Application for Planning Permission

Development: Retention of change of use of first and second floor office to an 5 bed HMO. This application is in CIL Zone 4 (Zero Rated) as other development.
Location: 51-51a Aldwick Road Bognor Regis PO21 2NJ

I regret that I am unable to accept your documents as a valid application until the following item(s) have been received or resolved :-

TITLE
Block Plan

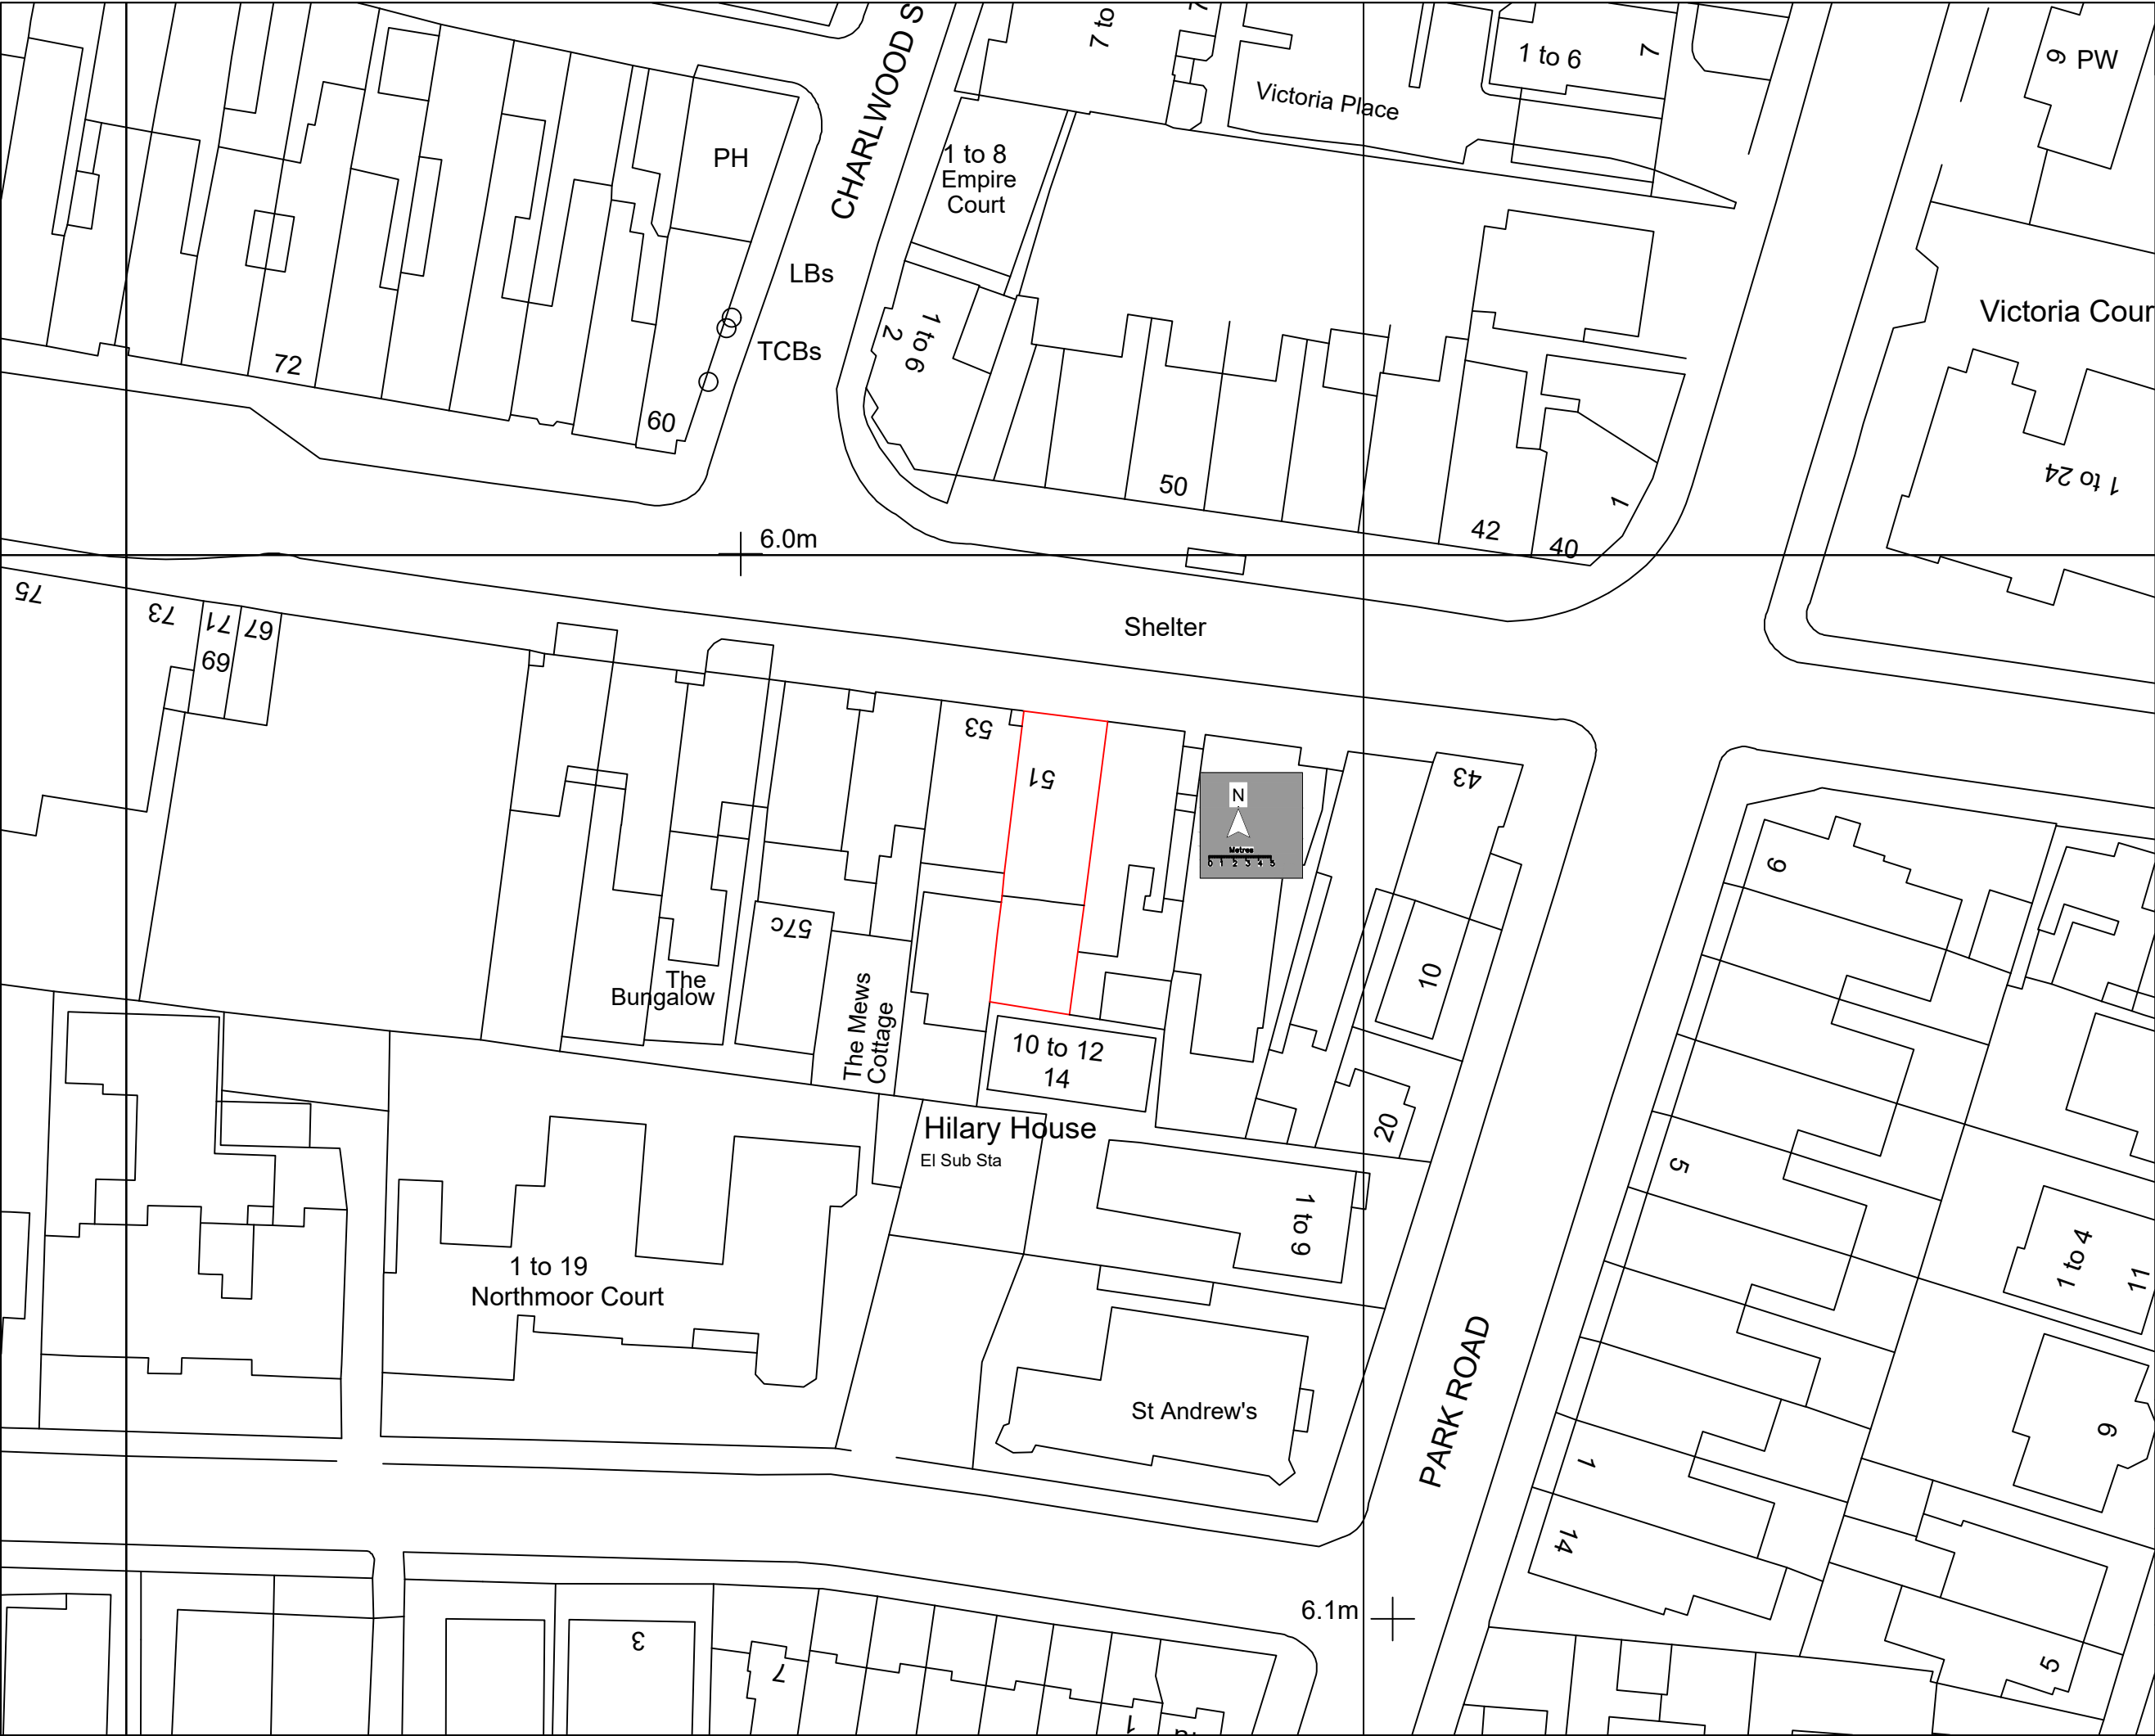
Block Plan

Please provide a north point.
